Recommendation Report for Planning Permission for Works or Extension to a Dwelling

REF NO: FP/148/25/HH

LOCATION: 2 Ormesby Crescent
Felpham
PO22 8EN

PROPOSAL: Pitch roof to the existing detached garage, new pitch roof porch and pitch roof dormer together with bow windows to existing windows to the front elevation and a flat roof dormer to rear elevation forming new bedroom suite and bathroom.

Title
Plans as Proposed

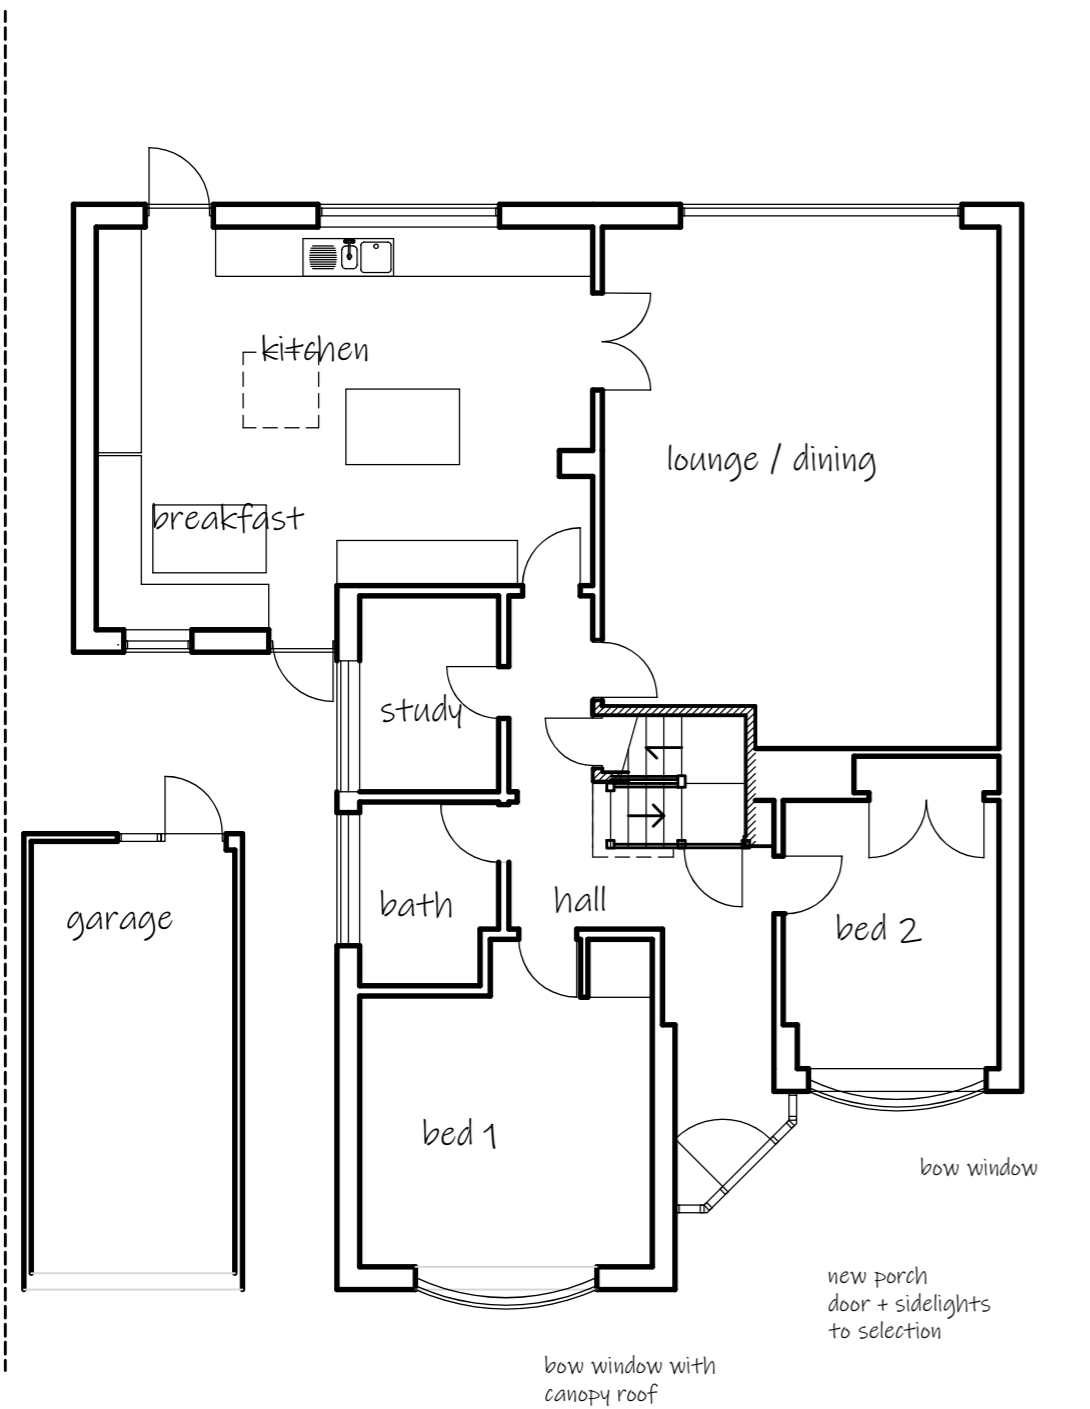
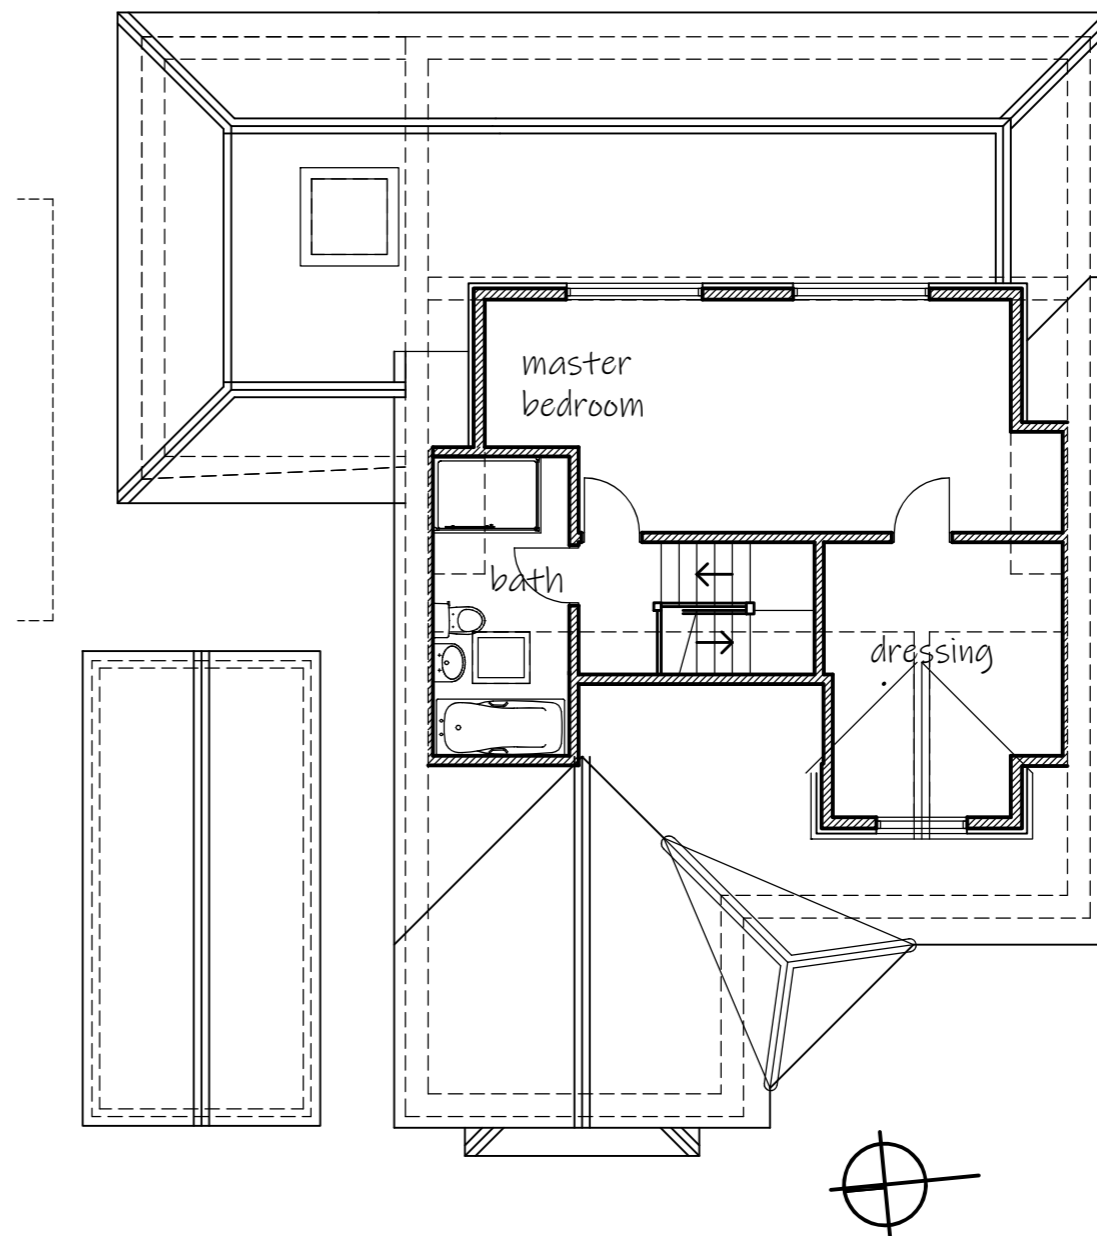
The proposed pitched roof to the garage would replace an existing flat roof. It would increase the bulk and massing of the garage close to the neighbour to the north. Notwithstanding this, it is noted that the garage is set in from the north boundary by approximately 0.3m at its closet point, and is separated from the habitable rooms by a similar detached garage with a pitched roof to the neighbouring property, and as such, given the spacing retained between the proposal and the neighbour to the north, the proposed replacement pitched roof to the detached garage would not result in overbearing or overshadowing impacts.

The proposed porch would be constructed to the front elevation, set in 4.6m from the south side boundary. The porch would not advance the existing building line and would not be visible from the north (side) neighbour. The porch would be set back approximately 11m from the highway. The porch would retain an acceptable distance from the other neighbouring boundaries, and the porch would not result in any overbearing or overshadowing impacts. The fenestration within the front elevation would have an outlook of the application site frontage. As such, the porch would not result in any overlooking.

The proposed front dormer would be contained within the existing front roof slope of the host dwelling and would be sited 2.3m from the south (side) neighbour and 10m from the north (side) neighbour. As such, the front dormer would not result in any overbearing or overshadowing impacts. The front dormer would introduce one window which would give rise to views of the front garden and the street with a distance of 13m to the highway. There is an area of public open space opposite. As such, the proposed front dormer would not result in harm by way of overlooking.

The proposed rear dormer would be contained within the existing rear roof slope of the host dwelling and would not result in overshadowing or overbearing impacts to neighbouring properties. Two windows are proposed within the rear elevation of the dormer which would provide an outlook to the rear garden of the host dwelling and would not result in harmful overlooking impacts given the rear garden depth is retained at 16.4m. Whilst some views of neighbouring gardens would be available from the rear dormer, these views would not be dissimilar to those which could be achieved by constructing a similar rear dormer under permitted development. As such, the proposed rear dormer would not result in unacceptable overlooking.

Alteration to the front ground floor windows is proposed. Two sets of bow windows would replace the existing. The fenestration would have an overlook of the front garden and driveway and would not give rise to any additional overlooking.

One rooflight is proposed to the front (west) roof slope of the dwelling which would serve the proposed bathroom and would not result in overlooking impacts.

Title
 Elevations as Proposed

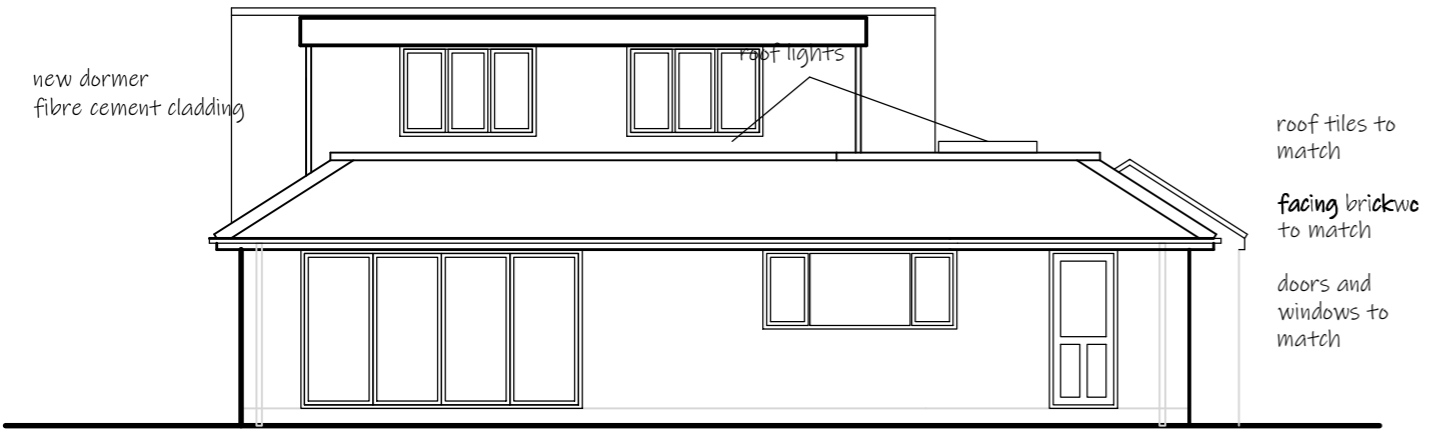
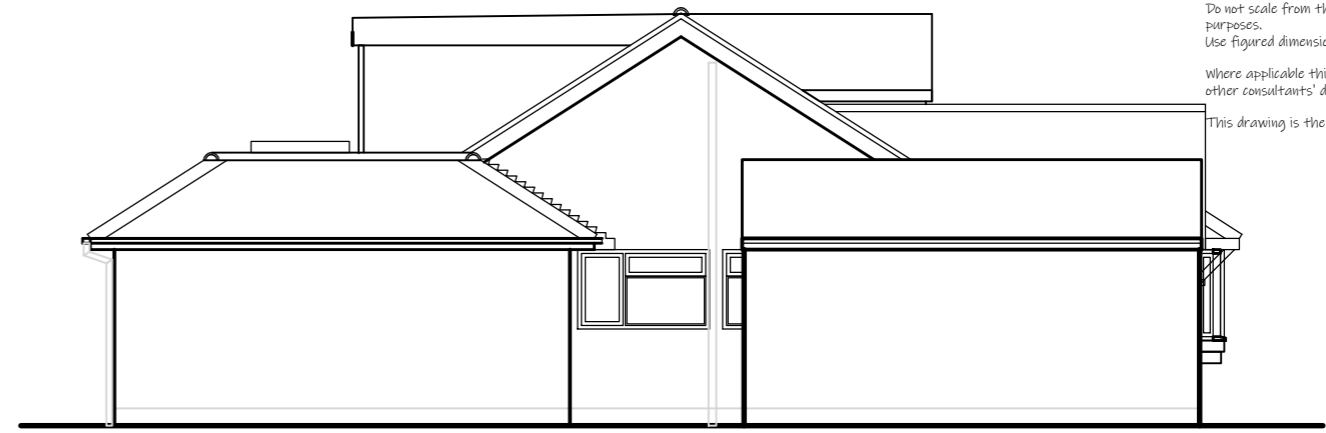
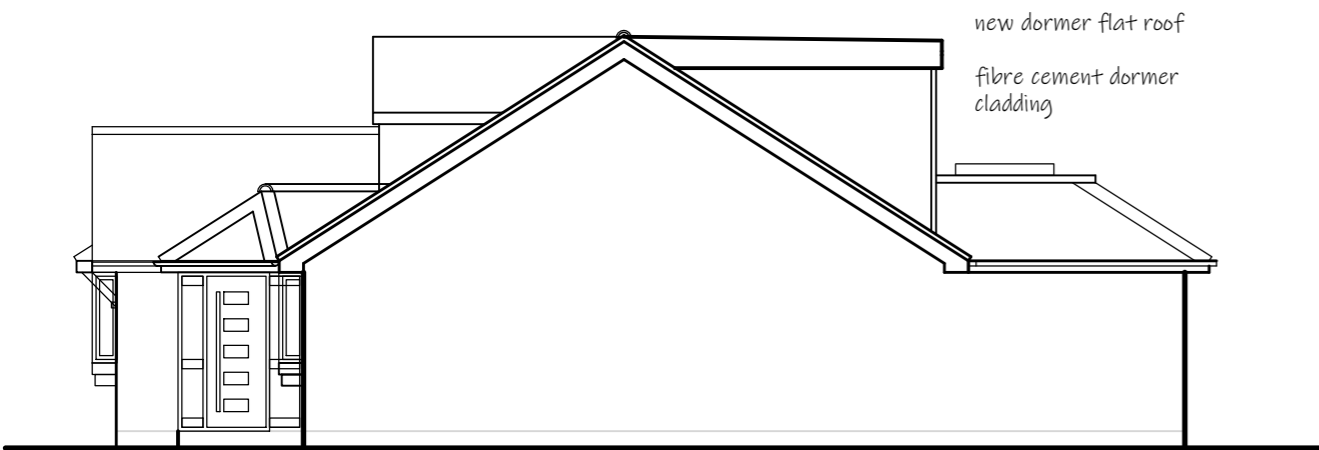
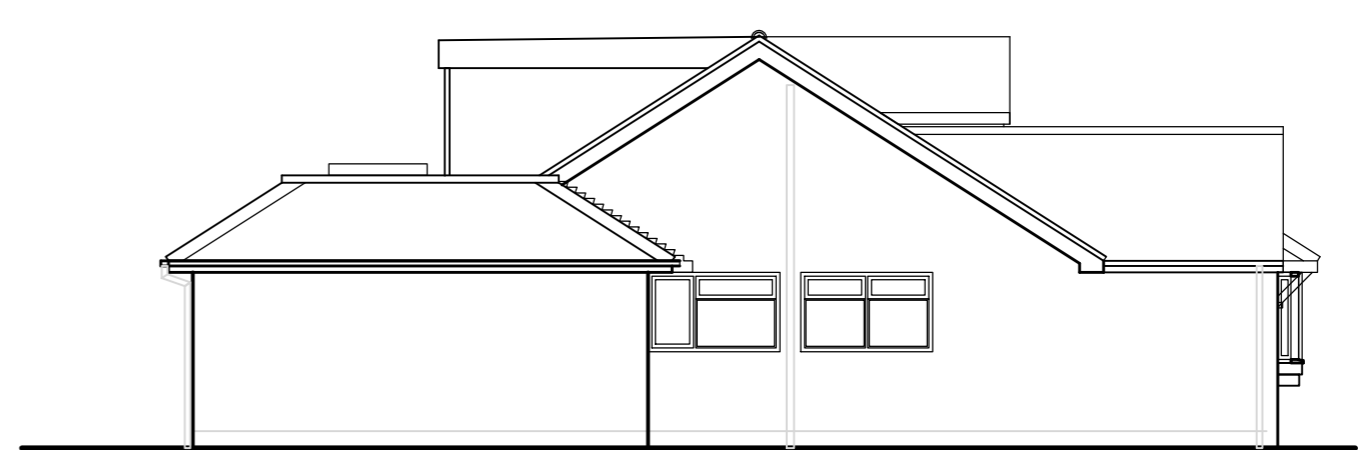
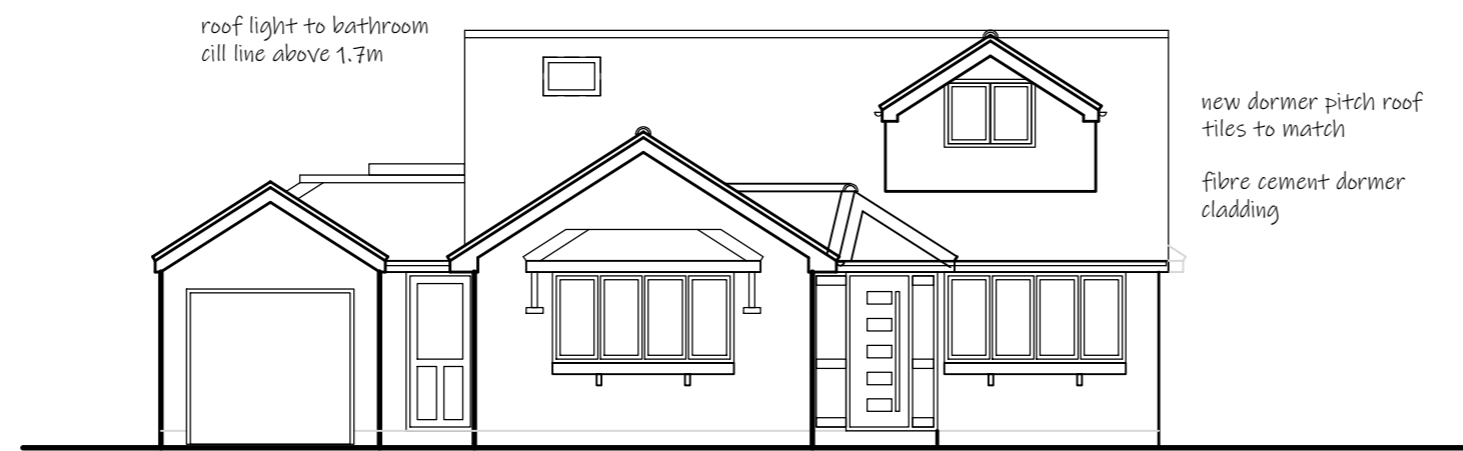
The proposed pitched roof to the detached garage would be in keeping with the street scene as a similar example of this is present at the adjacent neighbour, 4 Ormesby Crescent. Furthermore, the pitched roof design would match that of the host dwelling. Therefore, the proposed garage roof would not appear prominent or out of character within the street scene and would not result in harm to the character of the host dwelling, in accordance with policy D DM1 of the Arun Local Plan (ALP).

The proposed porch would be diagonally orientated and measure 1.6m at its widest and deepest points. The eaves height would match the existing, and the ridgeline would be set down from the front gable projection by 0.7m. The design is unusual however it is angled away from the street scene and would not advance the established building line. Therefore, the porch would not appear unduly prominent within Ormesby Crescent.

The proposed front dormer would measure 2.7m in width, 3.2m in depth and would have a pitched roof. The front dormer would be contained within the front roof slope of the dwelling which helps to minimise any visual harm upon the locality and complies with the Arun Design Guide (ADG). While there are no front dormers present along Ormesby Close, which is occupied by bungalows, there are a number of two storey dwellings opposite the junction with Wroxham Way and Somerton Green. The three storey building, Herons Court is sited less than 100m away across an area of public open space between the two sites. As such, the introduction of a front dormer at first floor level would not be harmful to the character of the area.

The rear dormer would measure approximately 7.2m wide, 4.1m deep, a height of 2.1m and would have a flat roof. Two windows are proposed within the rear elevation of the dormer. The development would alter the bulk of the property, however the main roof ridge height of the dwelling would be retained, and the development would not project beyond the original footprint of the property which helps to minimise any visual harm upon the locality and complies with the Arun Design Guide (ADG). Furthermore, a dormer of a similar size and scale could be constructed under permitted development. There is an example of a flat roof rear dormer at 10 Ormesby Crescent, and as such, the proposed dormer would not appear out of character within the street scene.

The proposed alterations to the front windows are small in scale and would not result in harm to the character or visual amenity of the host dwelling, street scene or wider area.

Title
 Roof Plan Proposed

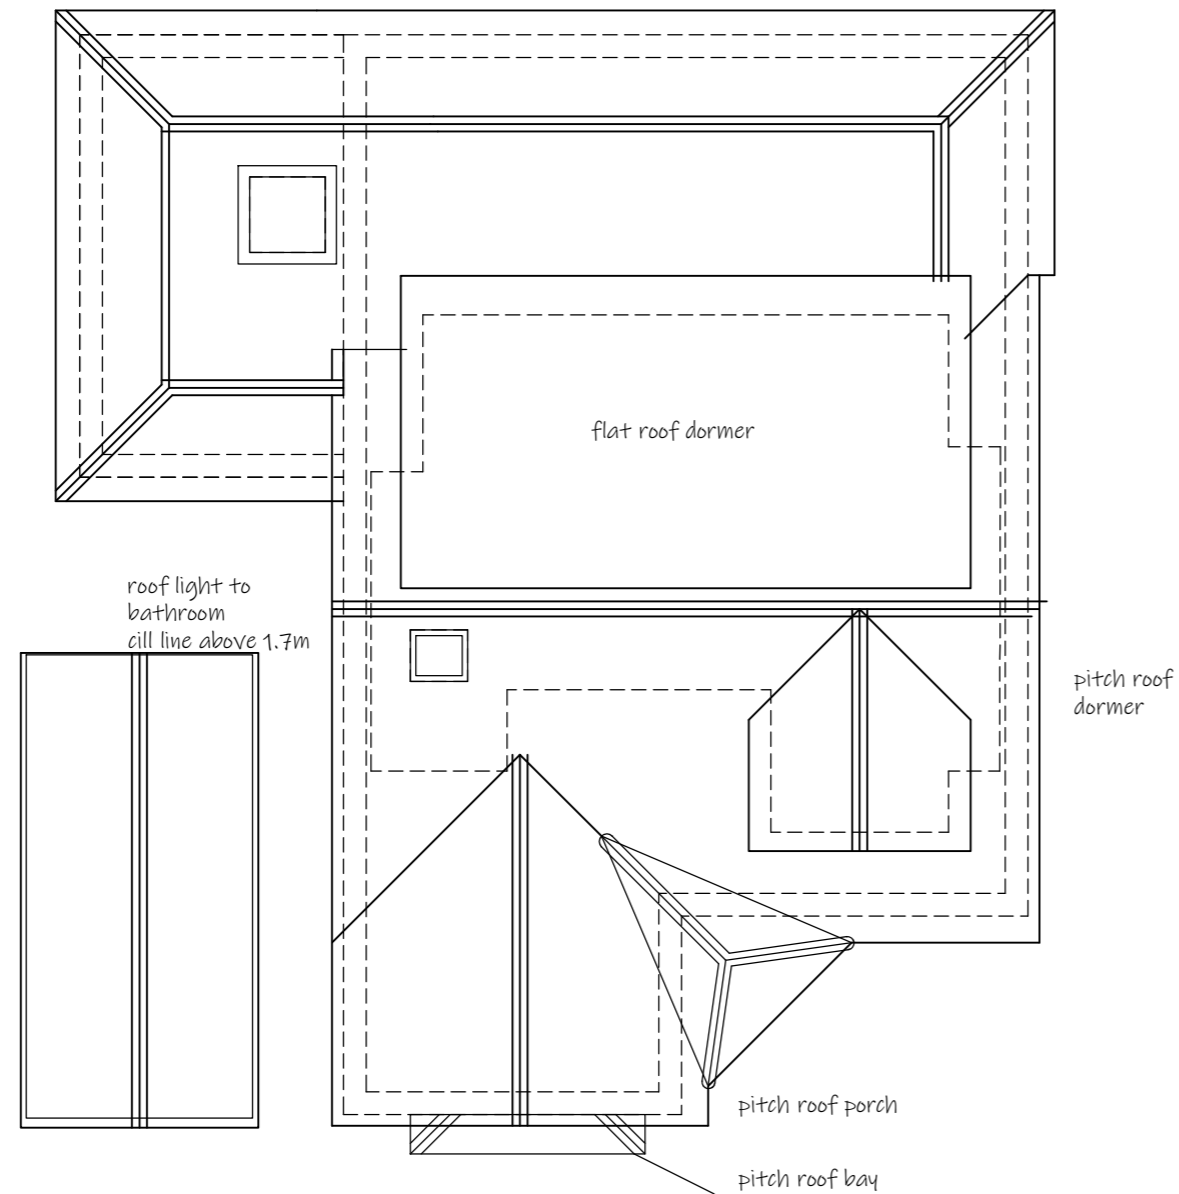
One rooflight is proposed to the front (west) roof slope of the dwelling. The rooflight would be proportionate in scale and would not result in any harm in this regard. Furthermore there are several examples of front rooflights in the vicinity.
